Appendix D Supplementary responses

COMMENTS REGISTER			
Project Name:		Panorama BESS	
Client Project Manager:		Christopher Smith	
SLR Project No:		660.v30234.00003	
SLR Project Manager:		Charlie Seventekin	
Revision:		v1.0	
Revision Date:		Wednesday, 16 April 2025

Route Assessment

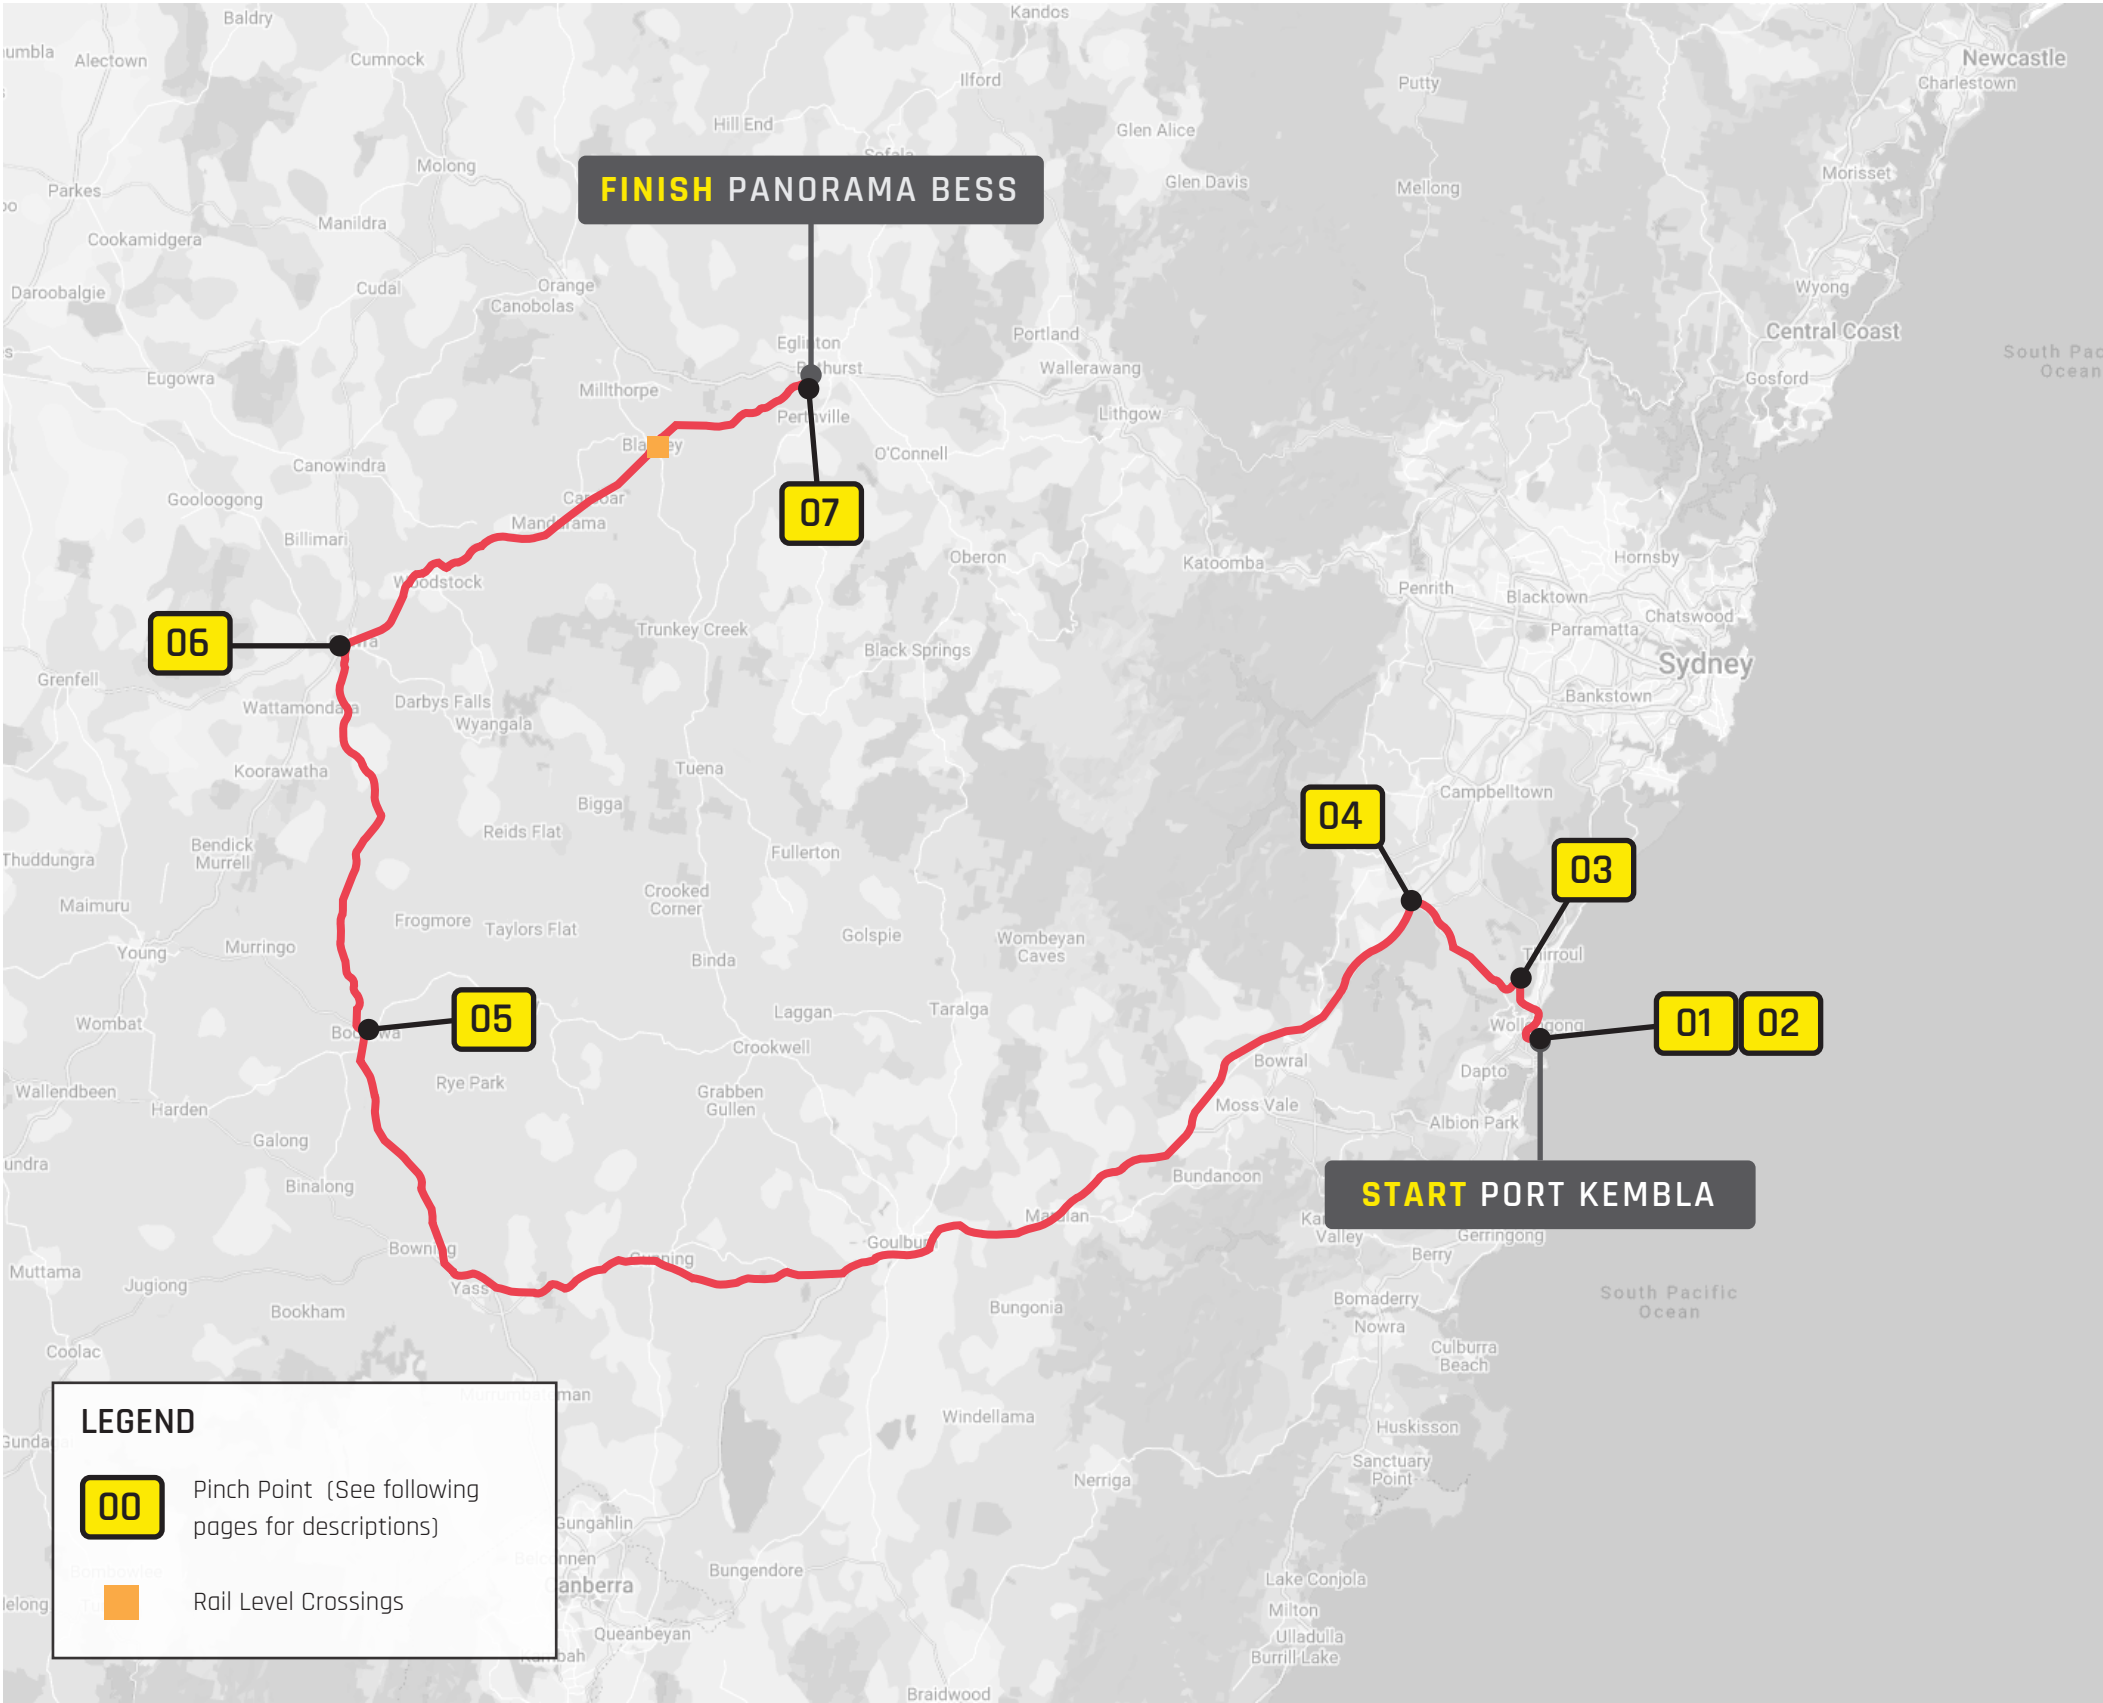
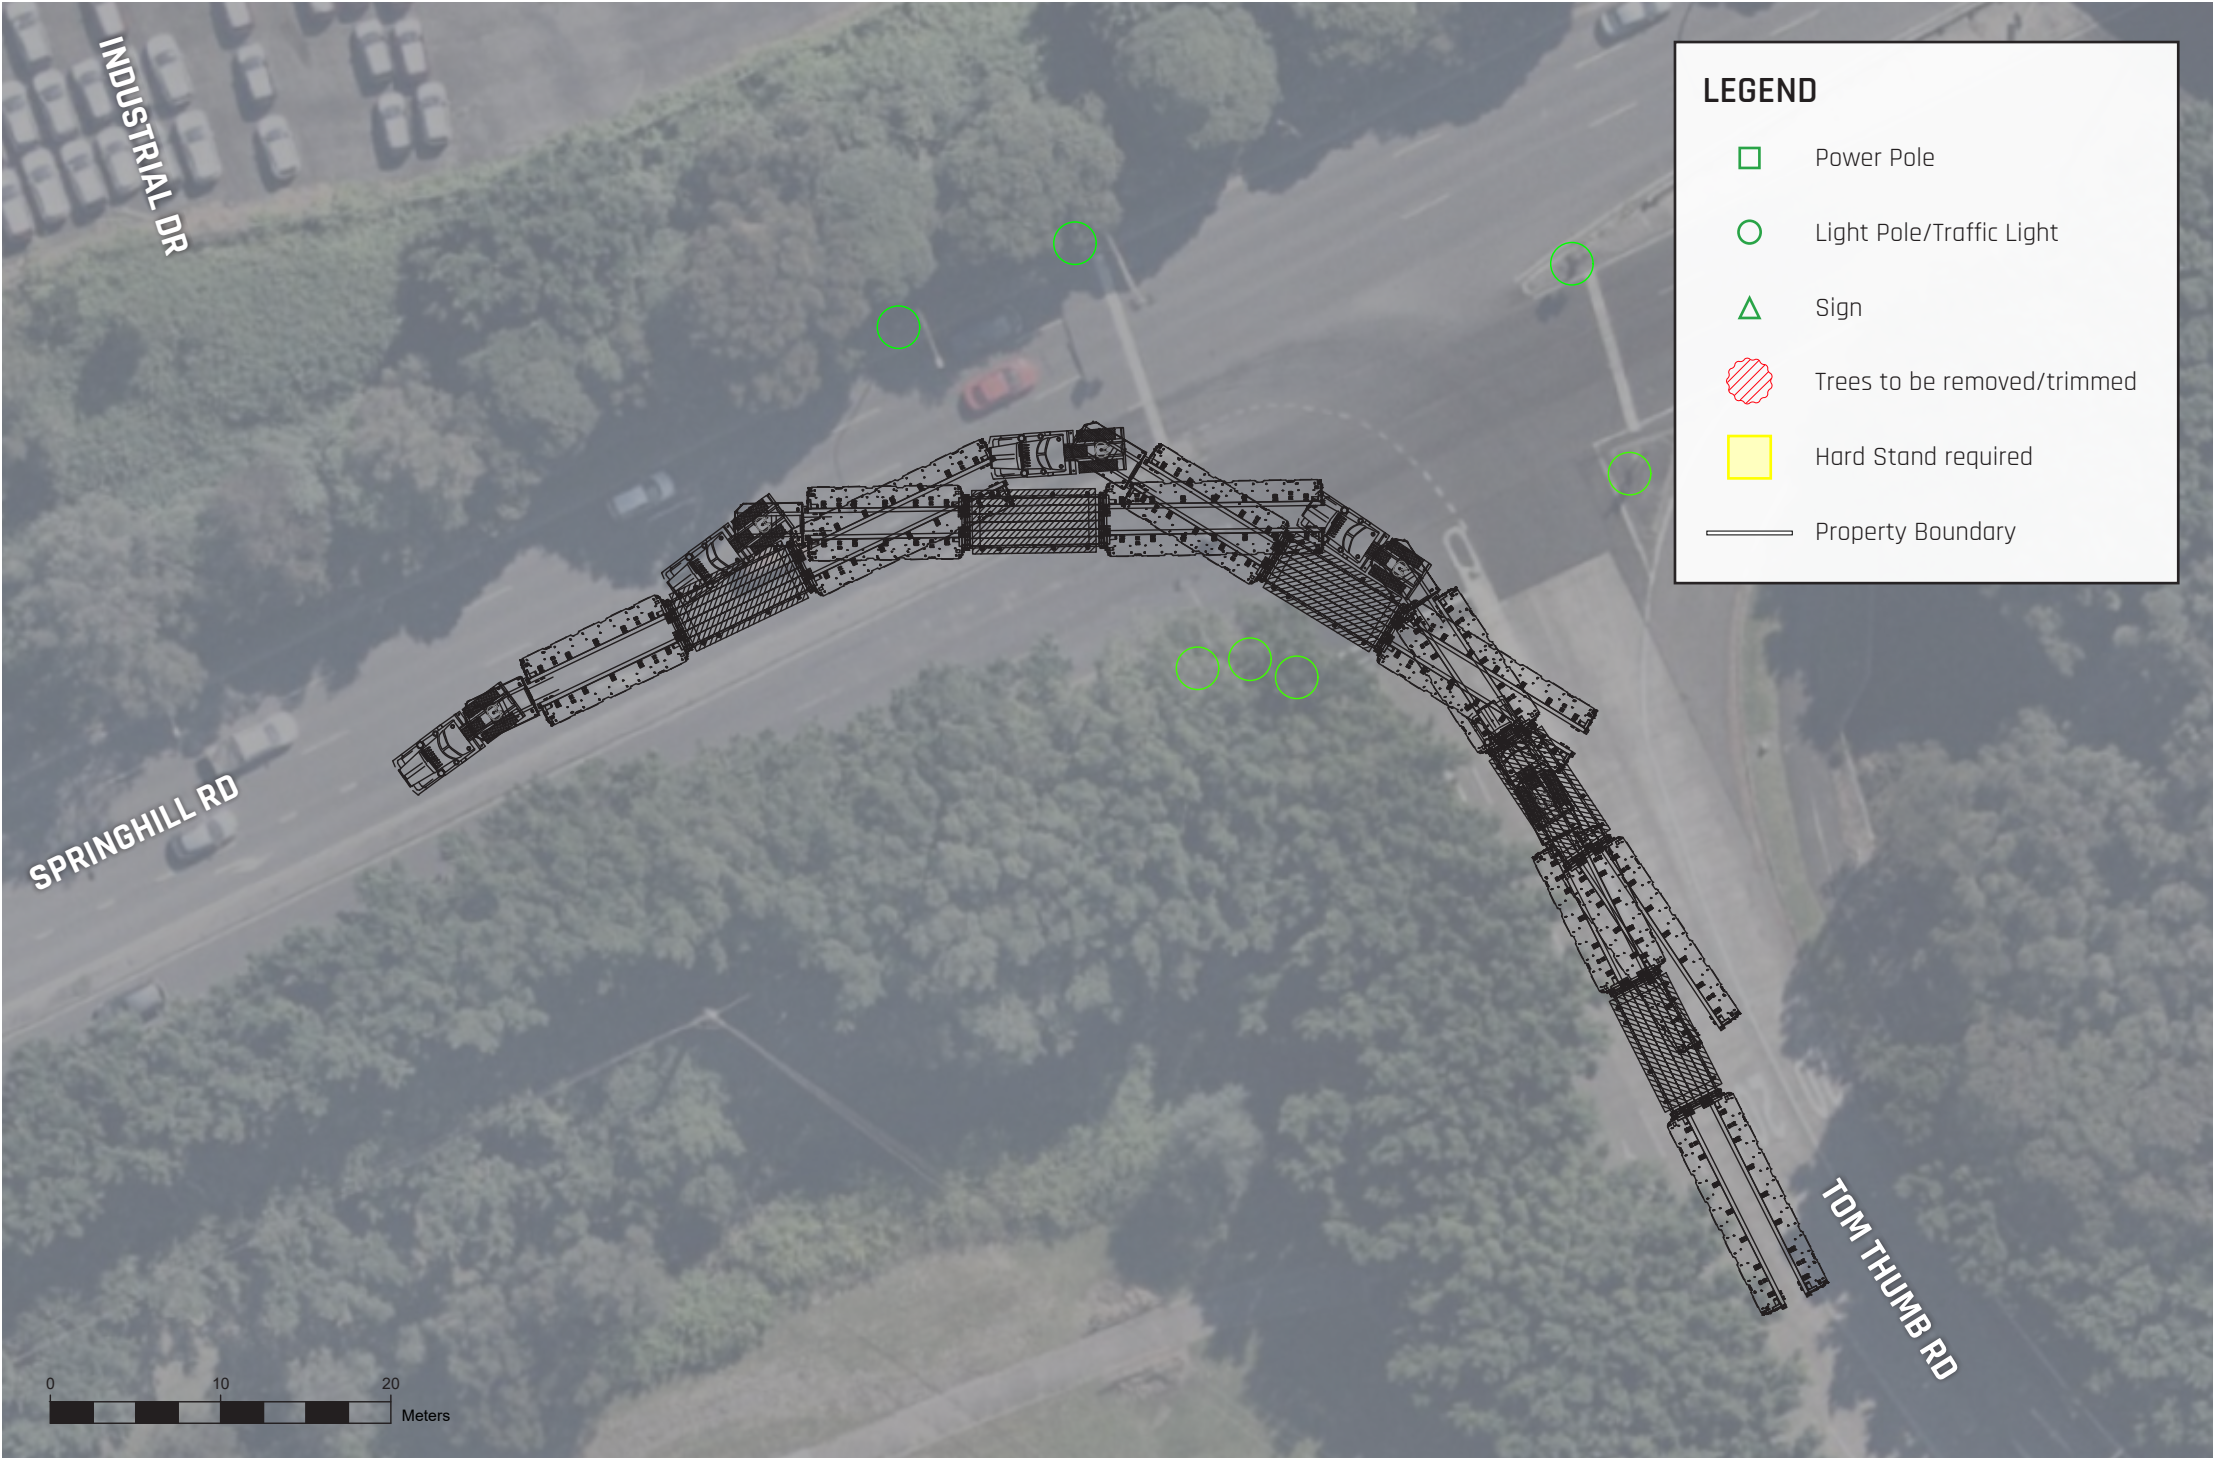
6	OSOM vehicle for the transformer is classified as high risk OSOM (as defined on TfNSW website in this link) due to its proposed height exceeding 5.20m. A Concept Level Route Analysis is required with the following information: • The route from port or point of origin to site access and intersections required to facilitate high risk OSOM movements required for the project. • Details of all high risk OSOM loads and vehicle configurations for the project. • Location of pull-over bays / rest areas along the high risk OSOM routes (including GPS coordinates) and demonstration swept paths of high risk OSOMs can be physically accommodated (in terms of size, width and accessibility). • Road geometry details and alignment along identified transport route(s), including existing formations, crossings, bridges, intersection treatments and any identified hazards, including: o Bridge Assessments for any at risk bridges on the classified road network due to dimensions and weight of OSOM vehicles. o Swept path analysis demonstrating the largest design vehicle can enter and exit the site and simultaneously pass through intersections along the proposed transport route(s). o Design vehicle templates used in the swept path analysis software in order for TfNSW to review performance (e.g. Autodesk Vehicle Tracking or Transoft AutoTURN). o Highlighting each at-risk road structures that haulage route(s) cross including bridges, traffic signals, signage, major culverts and minor culverts that may not meet desirable cover to cater for proposed axle loads. • Identify and provide the following measurement parameters of OSOM components / materials to be moved: o Types and numbers of high risk OSOM vehicles. o Overall combination type, configuration, load and vehicle configuration. o Wheelbase dimensions. o Length, width, height and mass (GCM, tare, weight to axle and payload) for components and nominated vehicles. o Maximum trailer articulation angle(s). o Minimum overhang heights above the road surface. o Vehicle configurations. o Traffic mitigation measures or road works, modifications or road upgrades to facilitate the movement of high risk OSOM(s). o Potential high level mitigation measures or commitments to mitigate known traffic, safety and impacts to road users along the high risk OSOM route(s) (i.e school bus routes, mining shift changes, TSRs, harvest periods and events). • Identify and assess implications of any road and rail projects that may be under construction during the indicative schedule for the OSOM movements. Note: NHVR permits do not cover road works or upgrades and environmental approvals required for proposed OSOM route(s). Any road works or upgrades works required along the OSOM route must be included within scope of works in the SSD to ensure constructability. Note: Given high number of renewable energy and other large scale projects requiring haulage of OSOM components on the road network, restrictions and limitations on OSOM movements may be imposed. In this regard, it is recommended you engage early with TfNSW's Development Services Renewables team to discuss the requirements of the route assessment.	ADDRESSED IN SECTION 2.5.4 and Appendix H.	Reference is made to TfNSW request in Section 2.5.4.
